Charlotte Department of Transportation

Memorandum

Subject: Rezoning Petition 08-035: Located on both sides of Statesville Avenue between Woodward Avenue and Dearborn Avenue (revised 12/20/07)

VICINITY MAP
Not To Scale

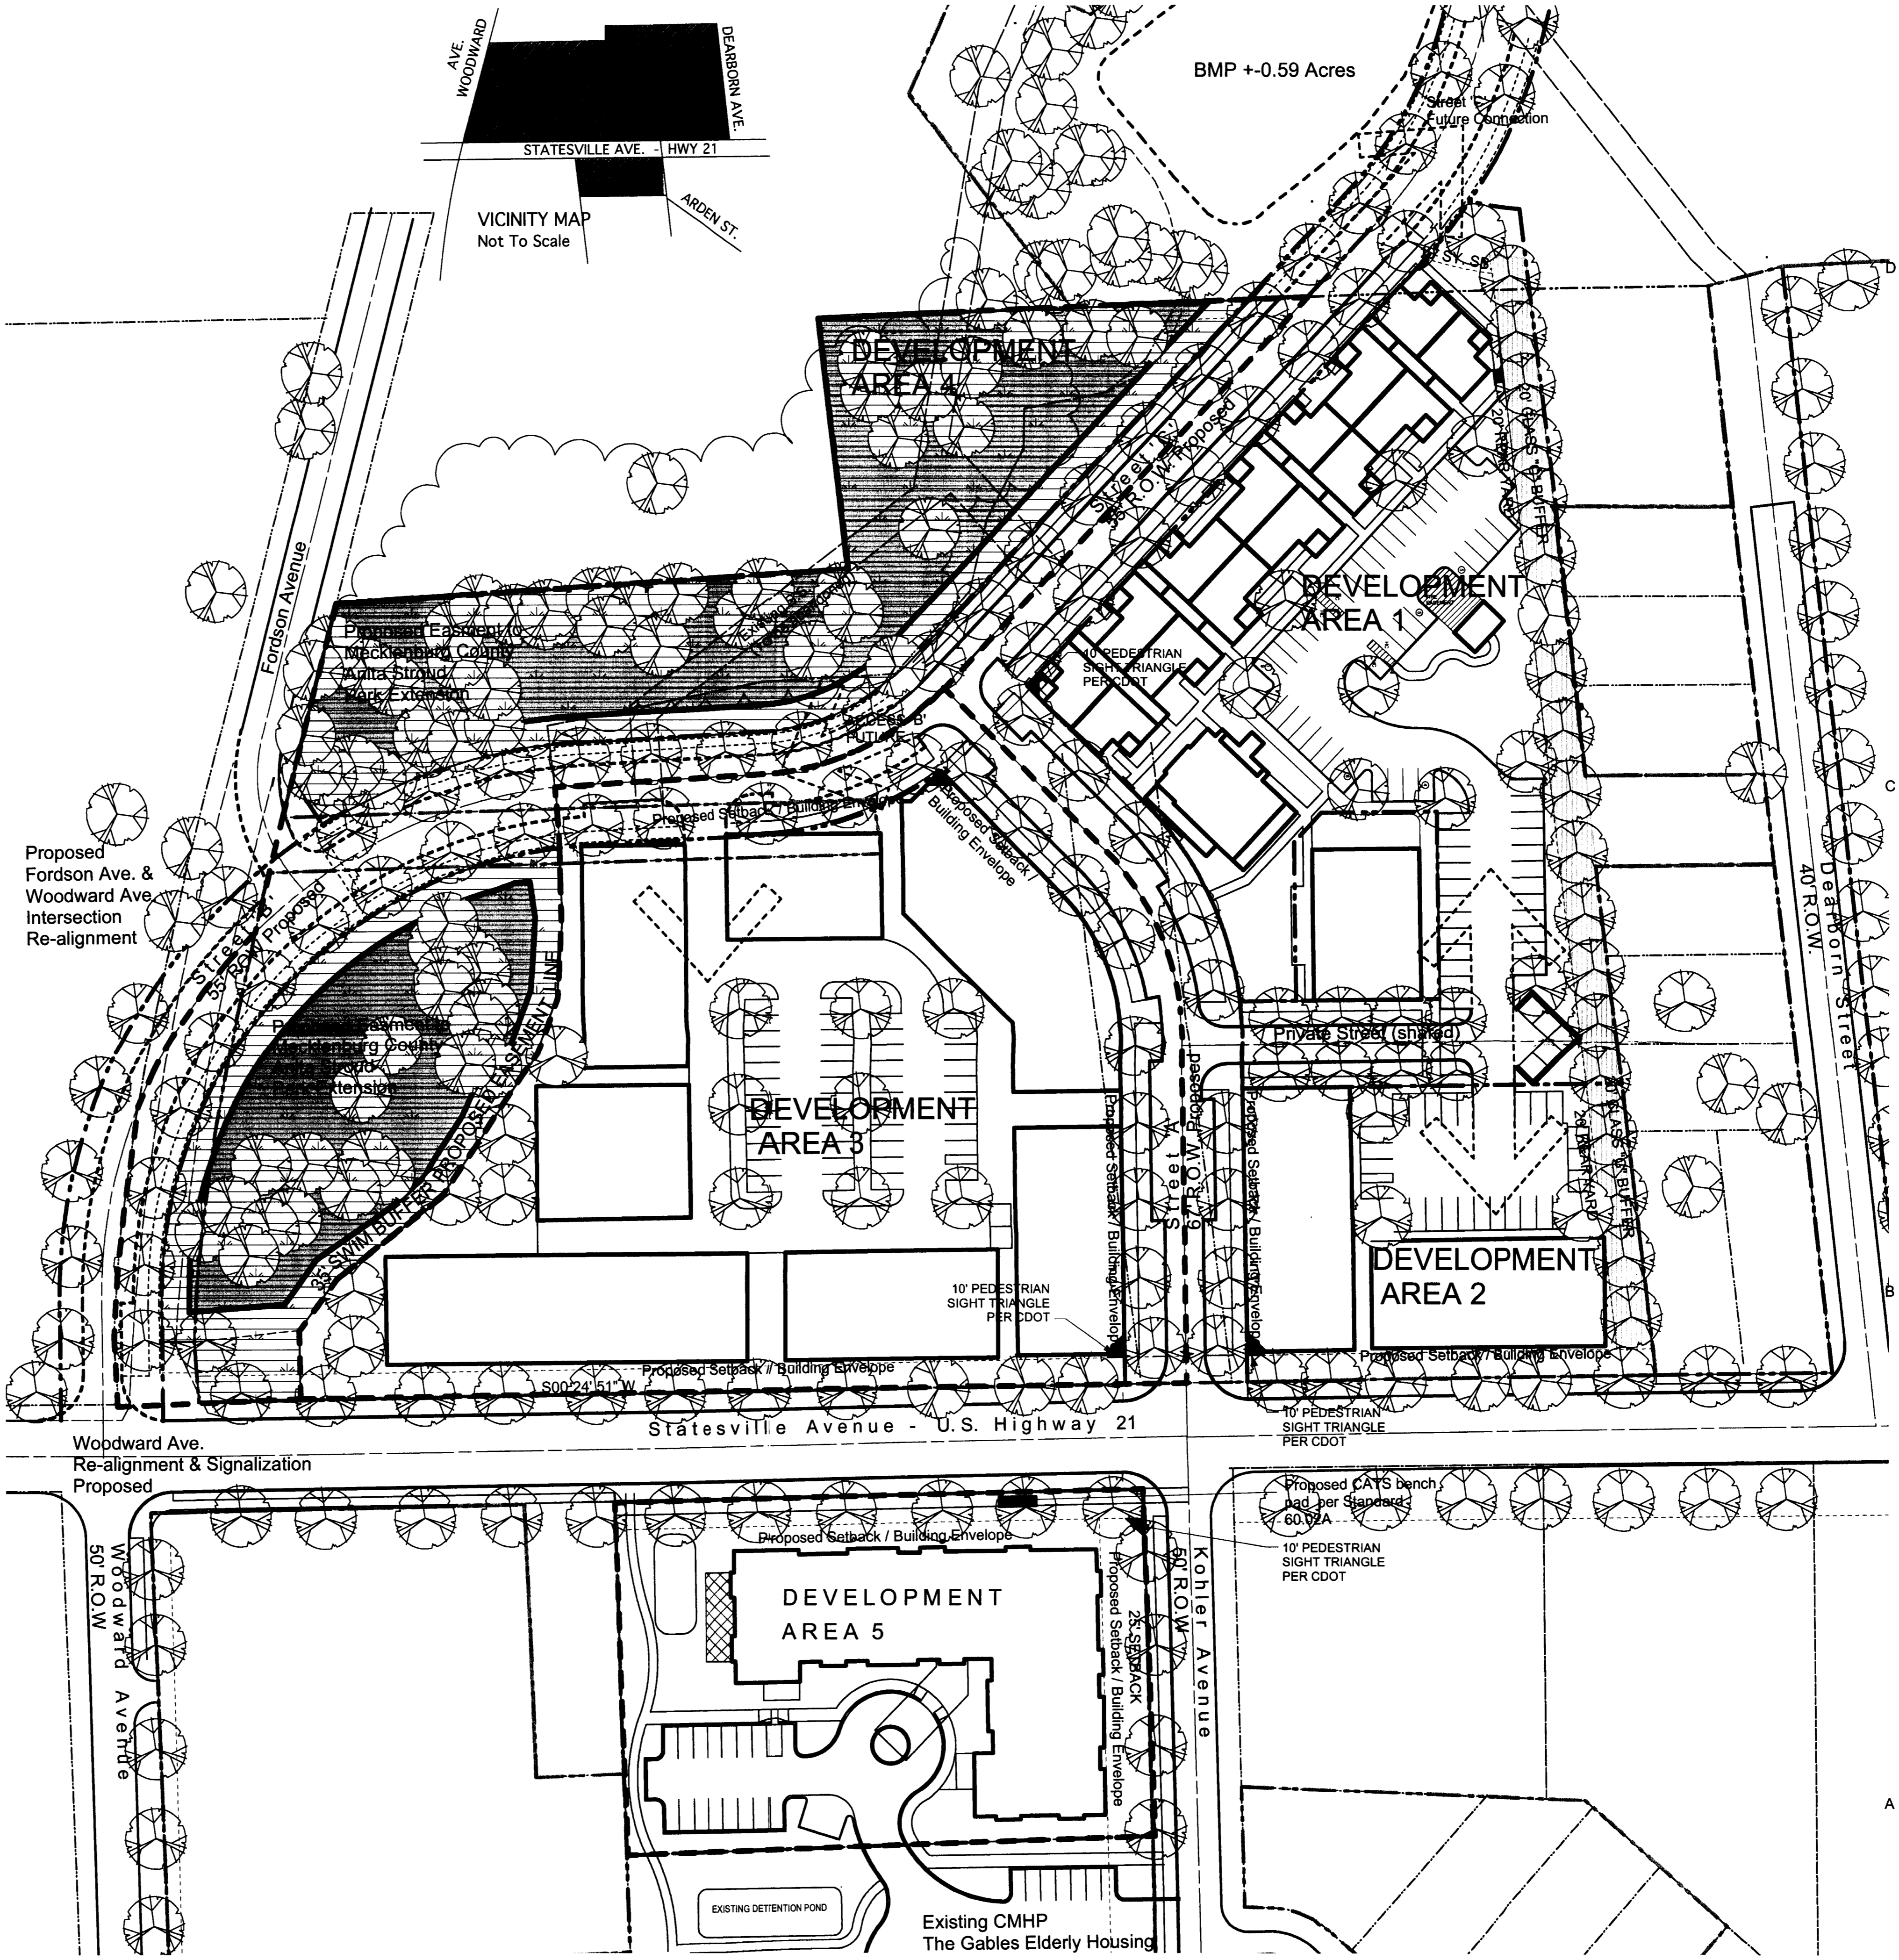
1. The site plan shows a proposed realignment of Fordson/Woodward Avenues to directly connect as the 4th leg of the existing Statesville/Woodward intersection. This proposed realignment and necessary improvements will be further reviewed by CDOT and the NCDOT during the review of the TIS. *(Previous review comment)*

2. The proposed realignment of Woodward Avenue is shown on an adjacent parcel (075-105-28). This property needs to be acquired before the realignment can be approved and noted on the site plan. *(Previous review comment)*

3. Development Area 1 on the plan shows a future connection to a future or existing street. This connection is too close to the intersection of proposed Woodward Avenue and this street and needs to be removed from the plan. *(Previous review comment)*

4. The proposed realignment of Woodward Avenue directly affects the access to an adjacent elementary school. The petitioner needs to demonstrate that the realignment will not adversely affect stacking for student pick up at the school. The petitioner needs to have discussions with the school/CMS and accommodate the needs of the school with their roadway design. *(Previous review comment)*

1. New streets need to be designed as Medium Local Residential Streets in accordance with the Urban Street Design Guidelines (USDG). *(Previous review comment)*
